Case ref: TR050008

### **Application by Oxfordshire Railfreight Ltd for an order granting development consent for the Oxfordshire Strategic Rail Freight Interchange**

#### **Advice following issue of decision to accept the application for examination**

Drawing file: published-documents / TR050008-000287-Document 2.8E - OxSRFI-BWB-LSI-05-DR-CH-0185_Highway Classification Plans Sheet 05-P03.pdf

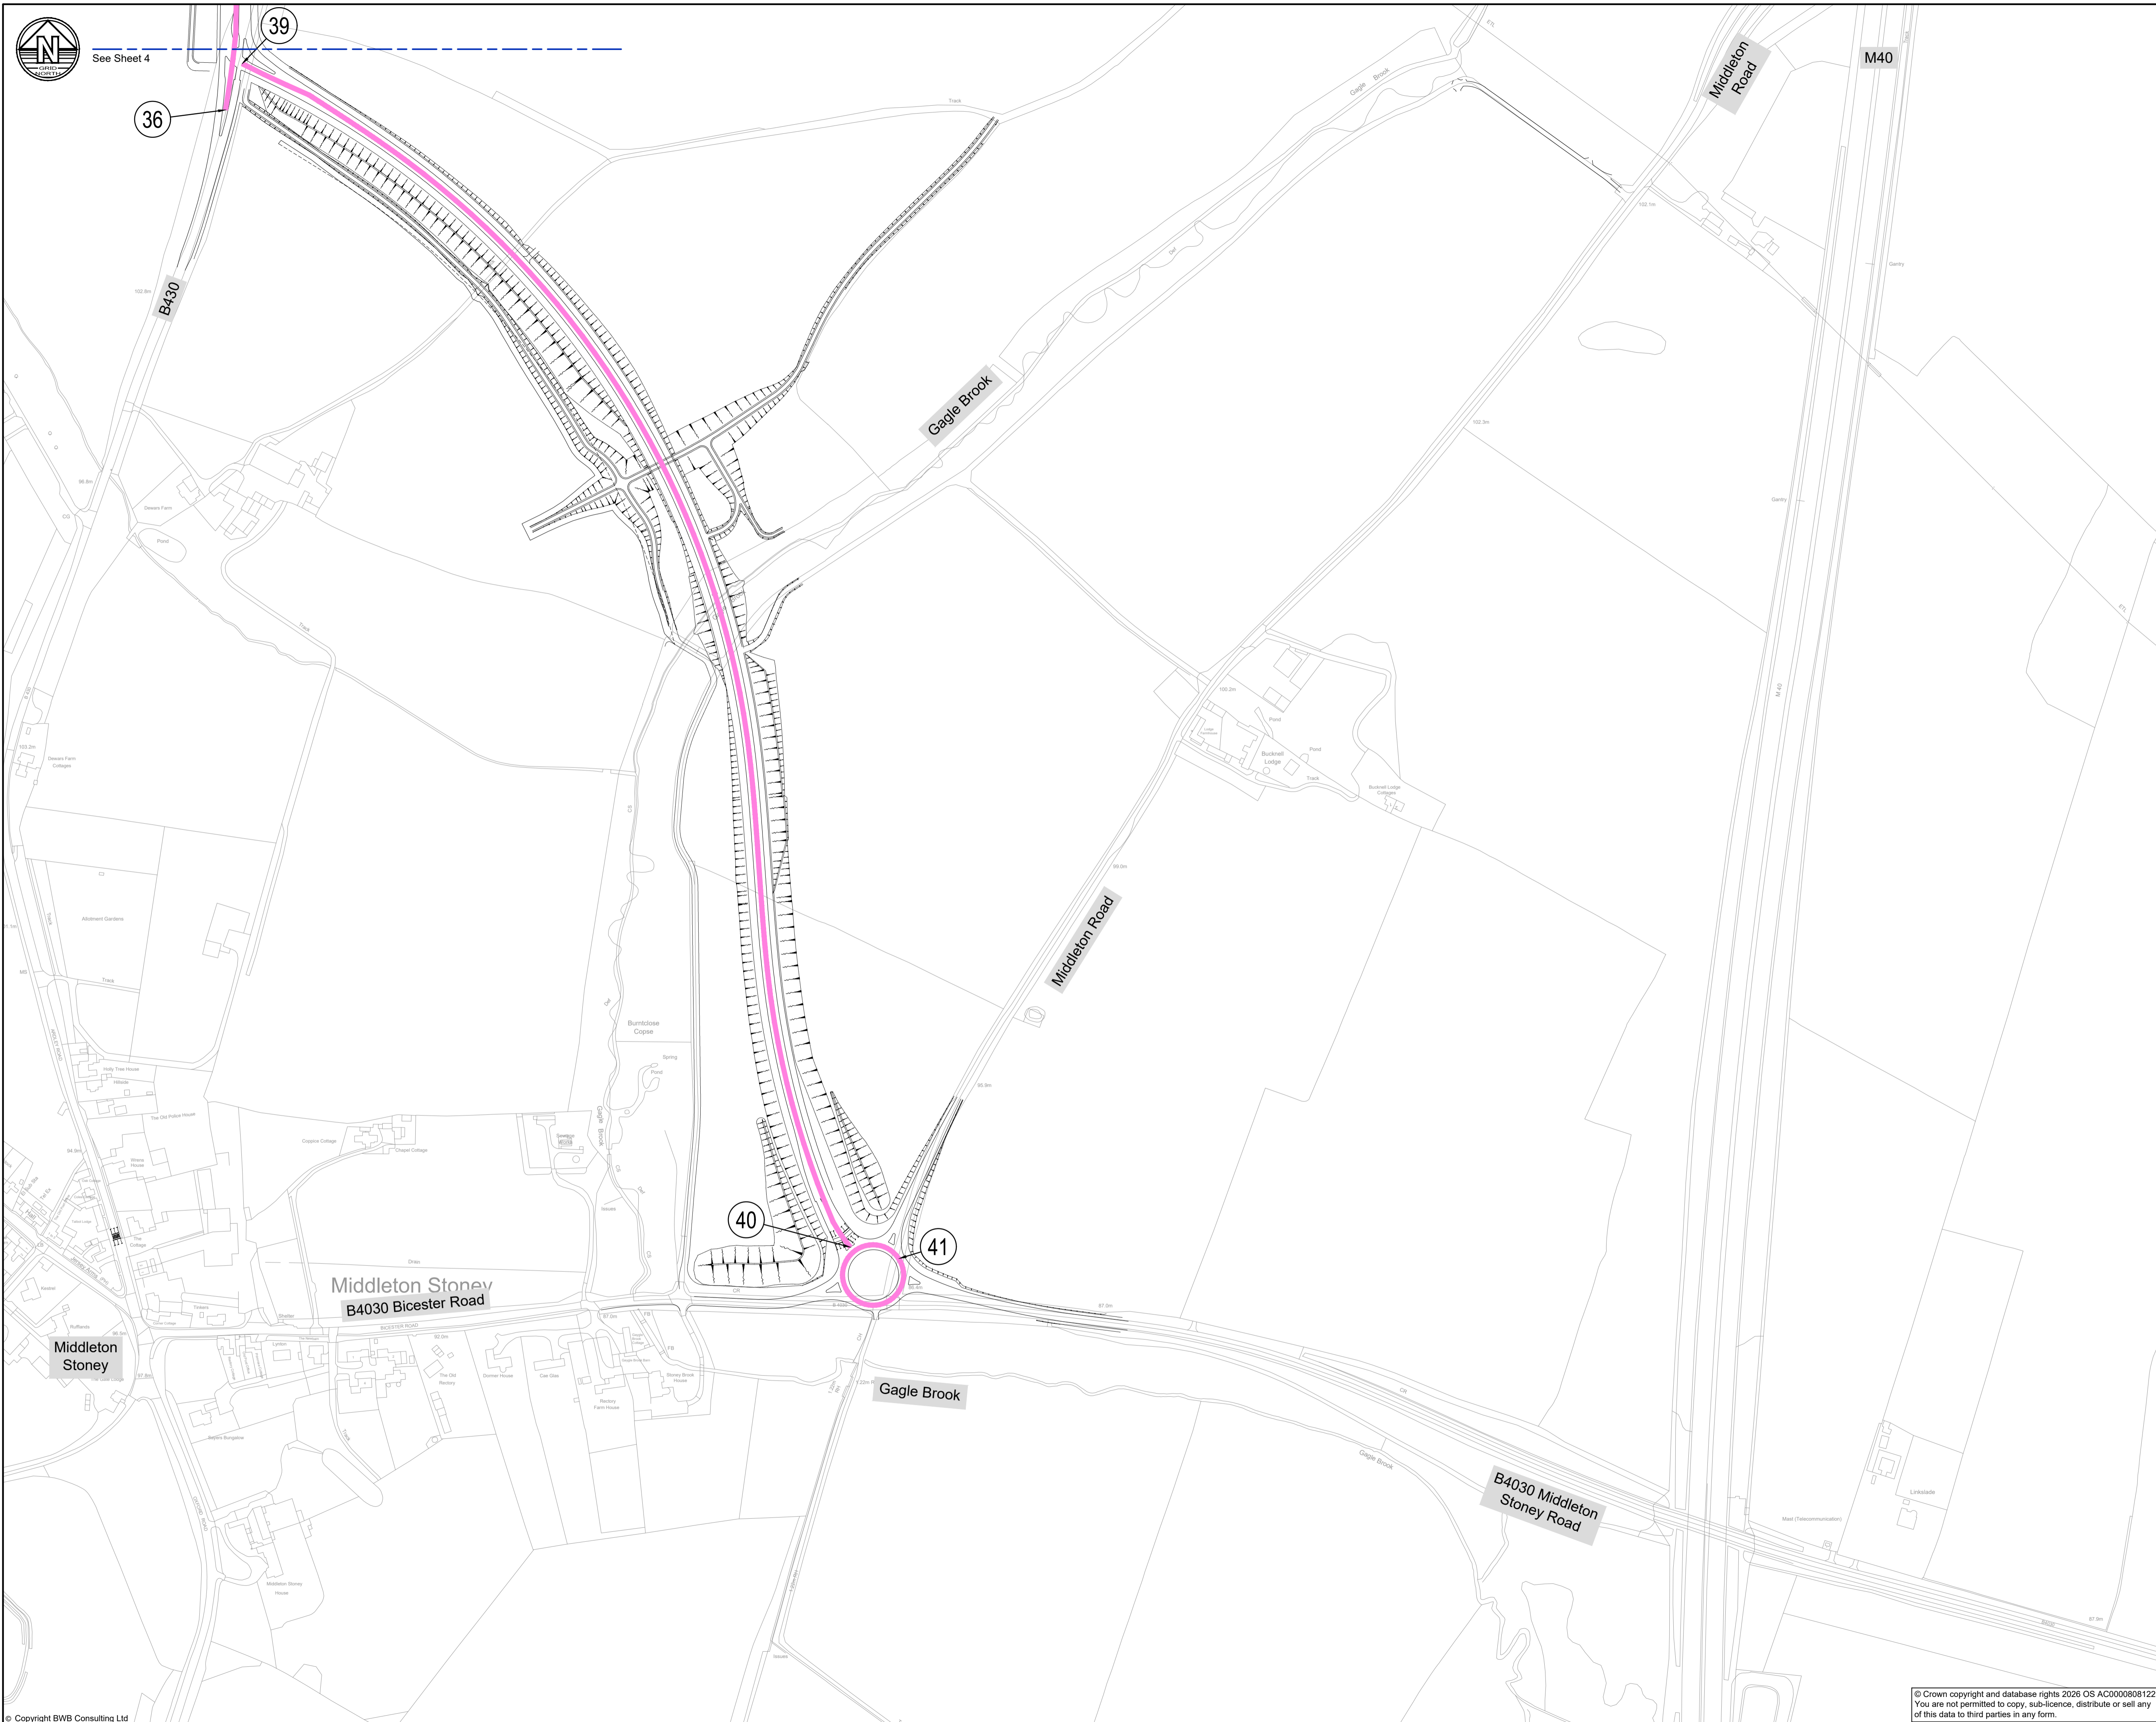
Documents 2.8A to 2.8E Highway Classification Plan Sheets 01 to 05: the label on the legend should include reference to the relevant schedule(s) in the DCO as is the case with documents 2.9A to 2.9E. The document could be improved by adding all road numbers and names.

01 Long Section as Proposed
 2111 1:100 @ A3

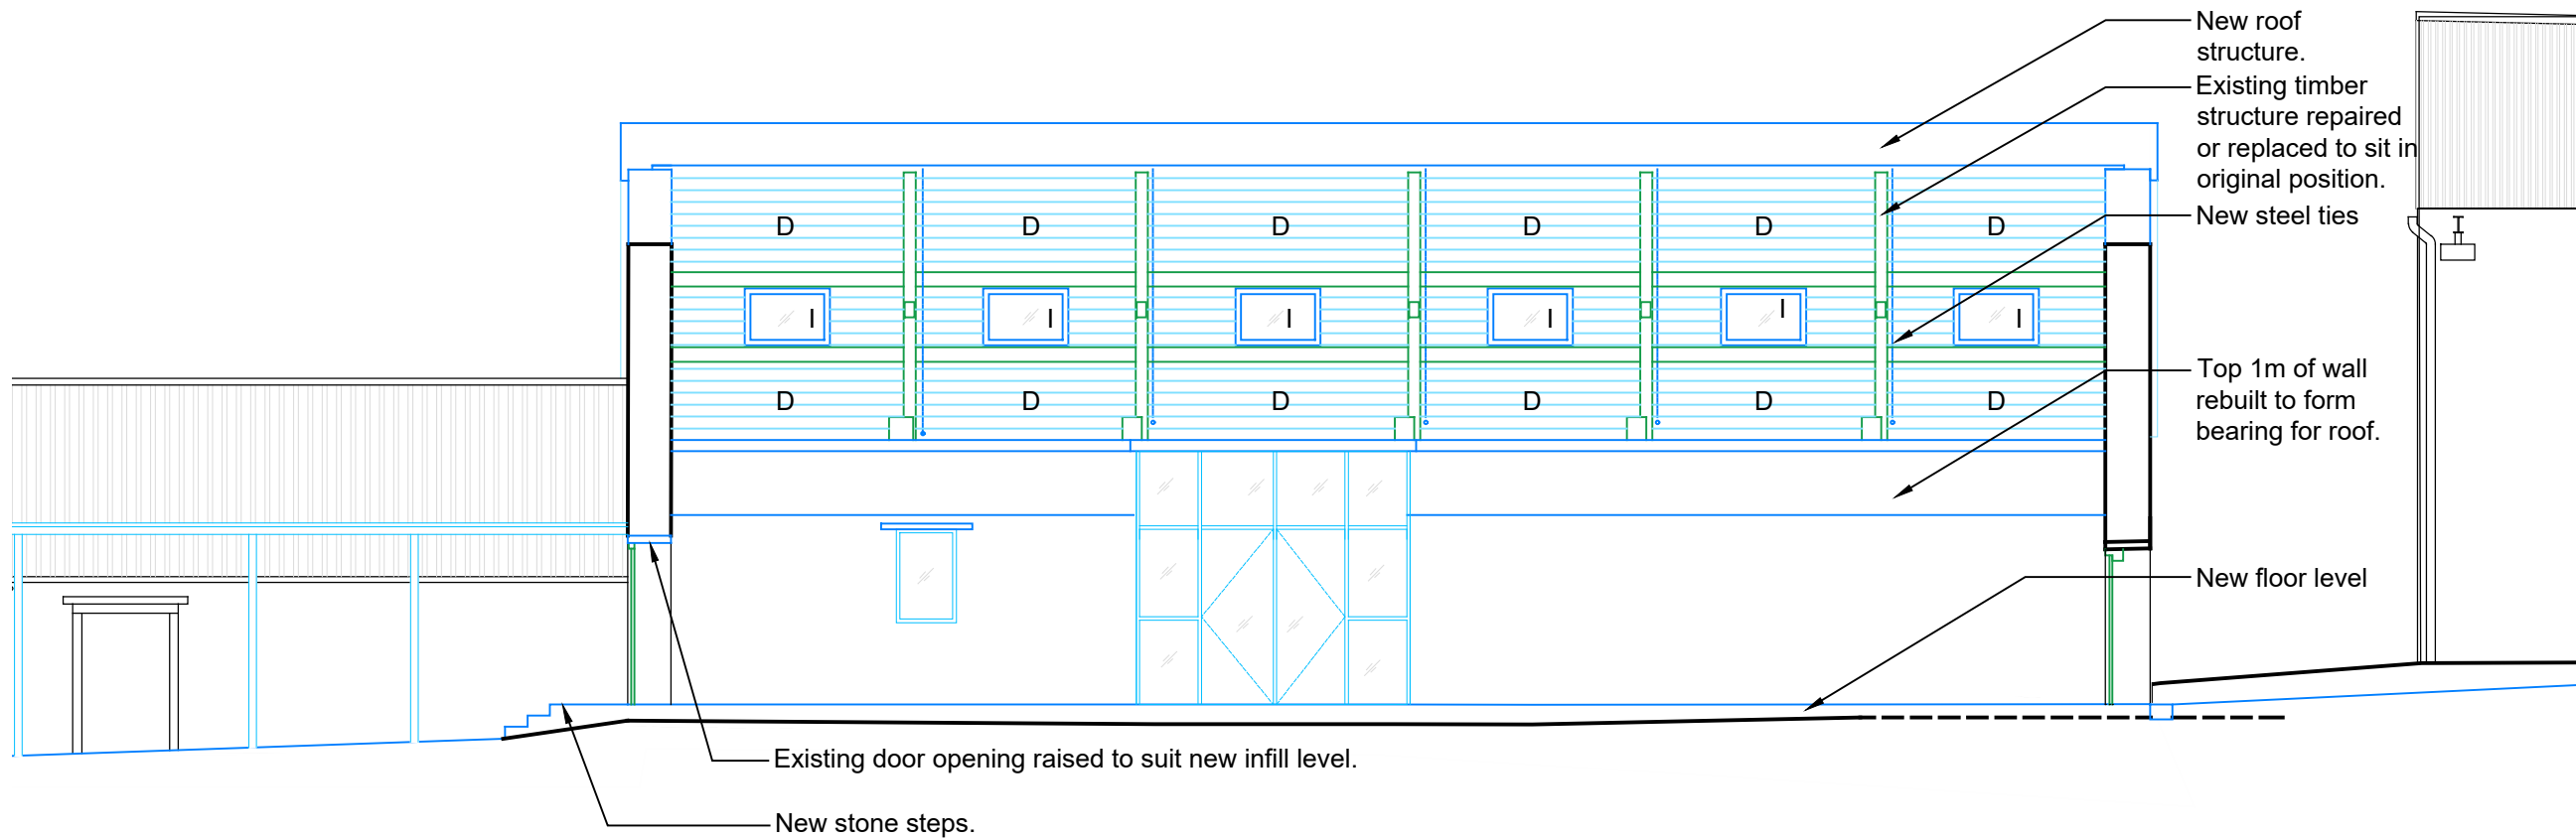
Plan series 2.14 (Listed Building Plans) needs to have Listed Building Plans explicitly stated on each plan, in the same way as for example Works Plan and Land Plan.
